Drainage Report Final_V1.pdf Markup Summary

FINAL DRAINAGE REPORT
FOR
LOT 5 OF CLEARWAY **FILING NO. 2**
EL PASO COUNTY, COLORADO

Project #44-042

Update to PCD File
No. PPR-2234

DETAILED GRADING PLAN

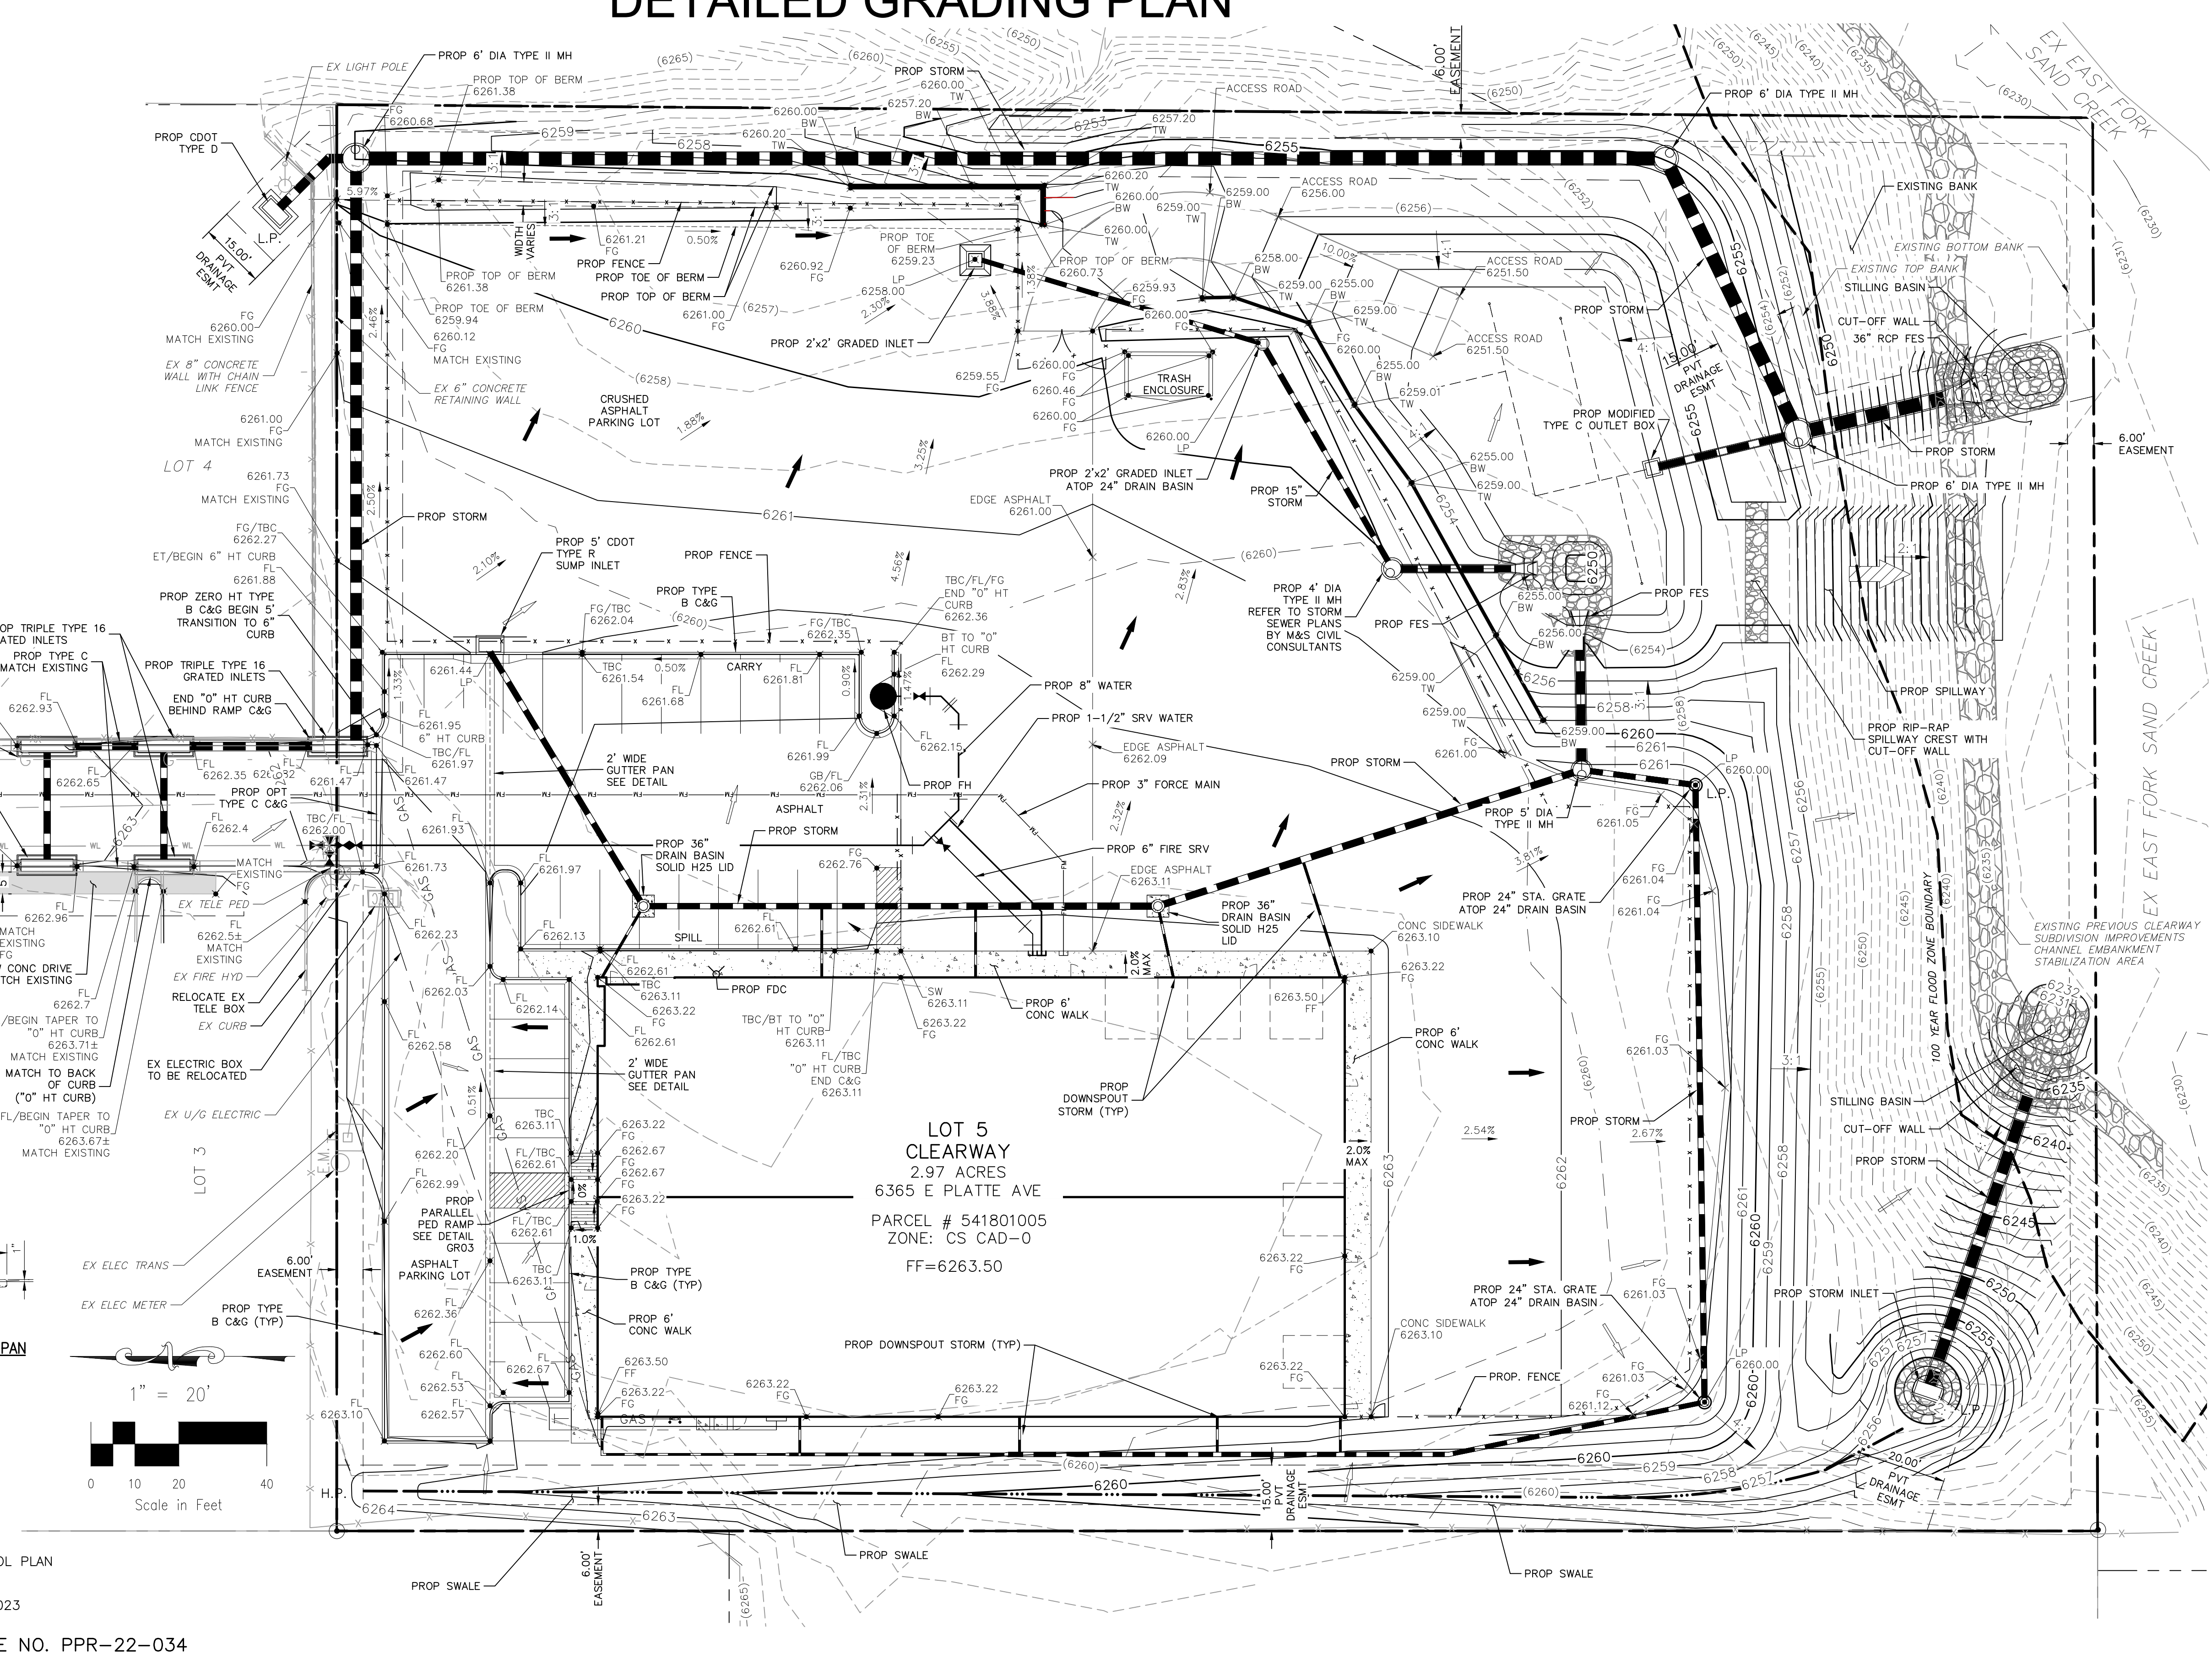
please tie the proposed contours with existing. typical throughout the plan

Proposed grades for Basin O do not seem to divert all stormwater to DP-9. Adjust contours so that all SW will drain to DP-9 for WQ treatment

SPILLWAY SECTION D-D  
NOT TO SCALE

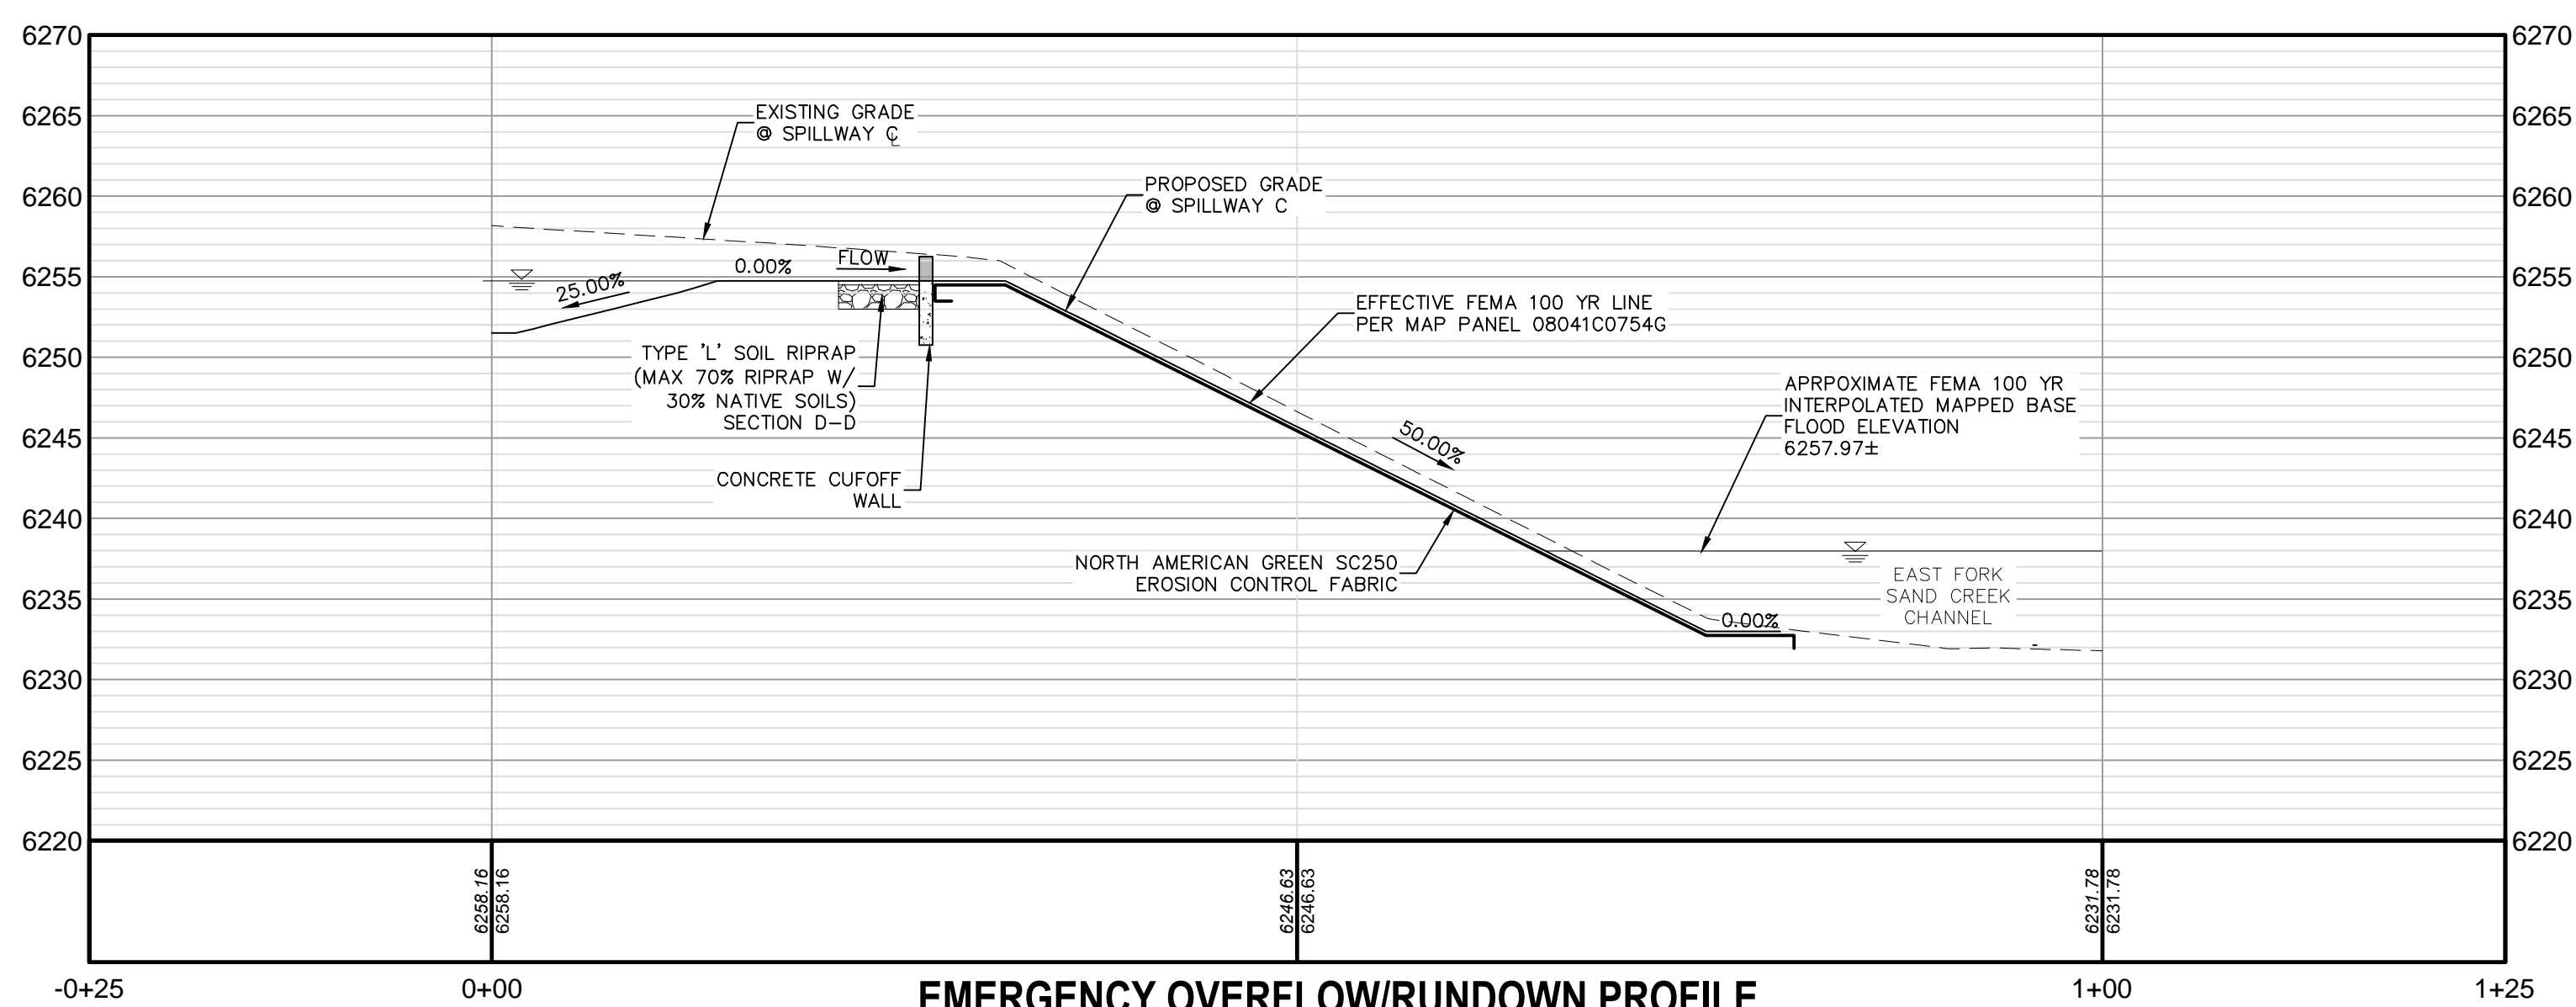
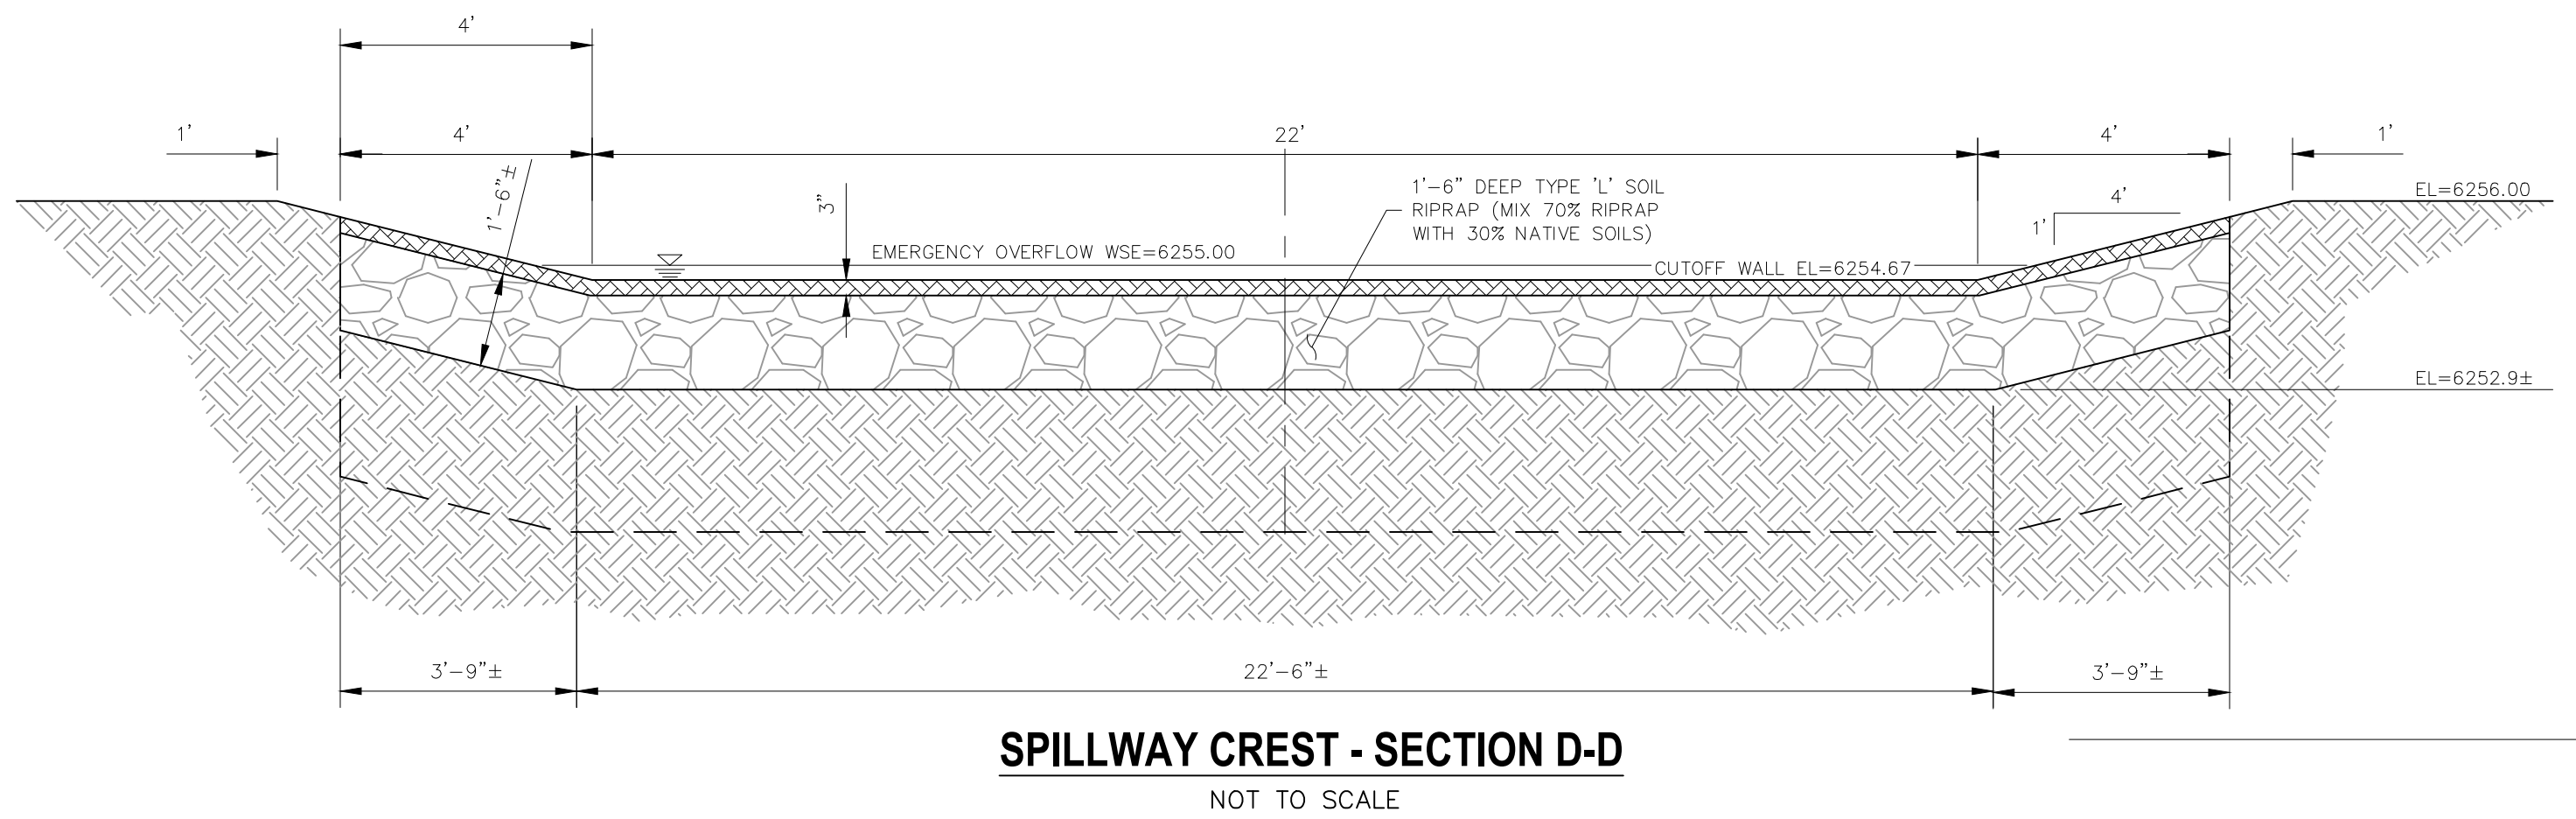
label the spillway and protection and provide design analysis of the spillway conveying the undetained rational flow and the protection down the embankment

POND STILLING BASIN PLAN VIEW

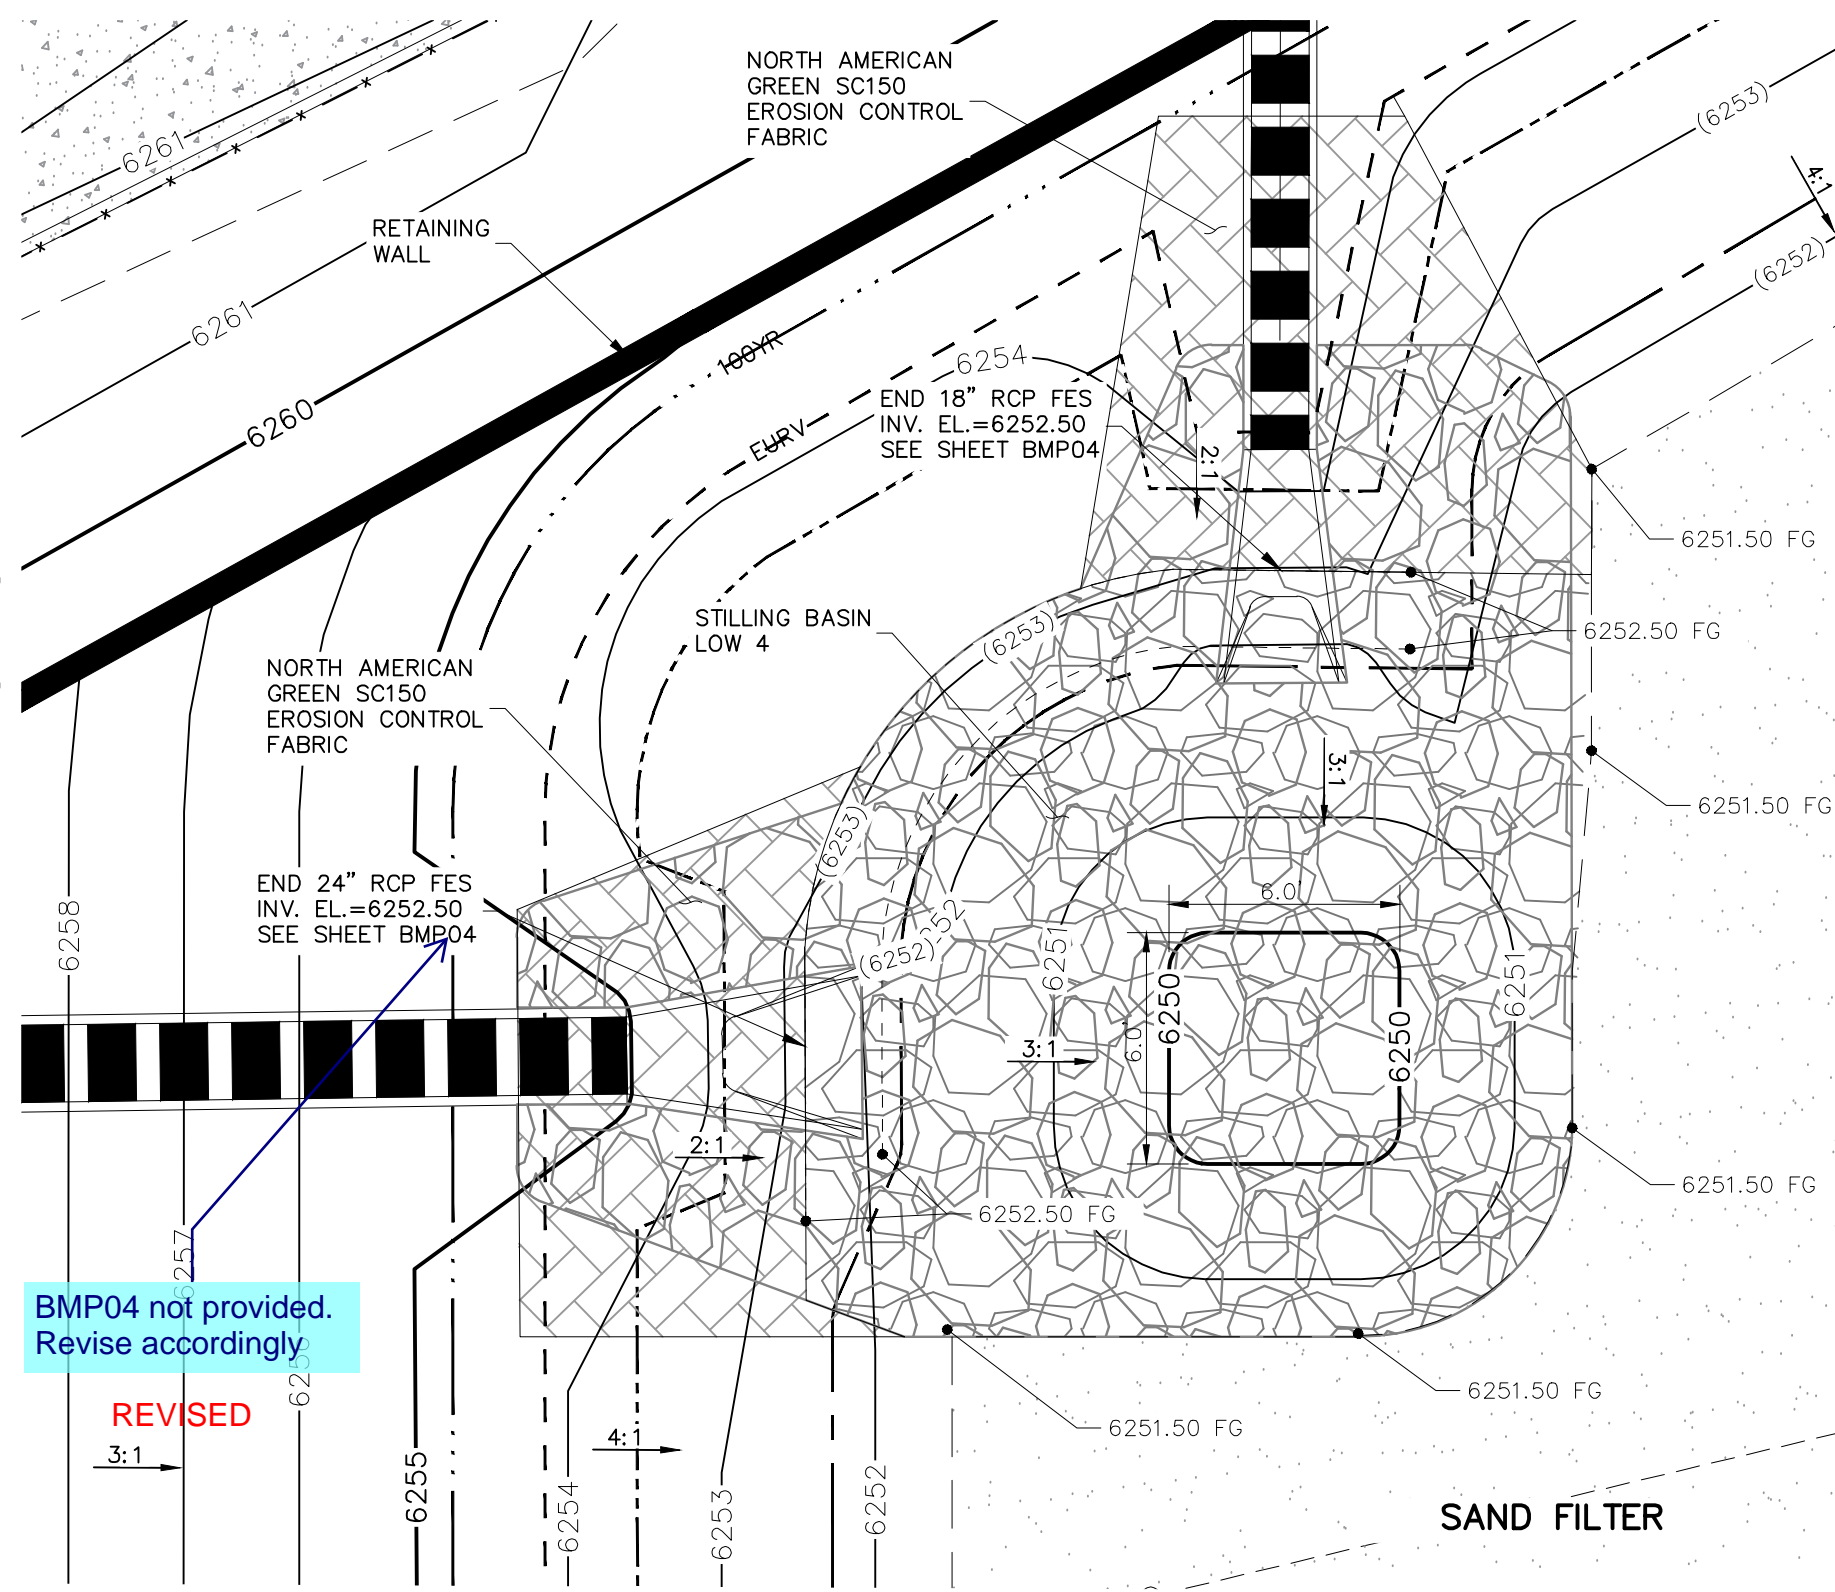
please label the proposed stilling basins with proposed specifications throughout the plans and provide design analysis
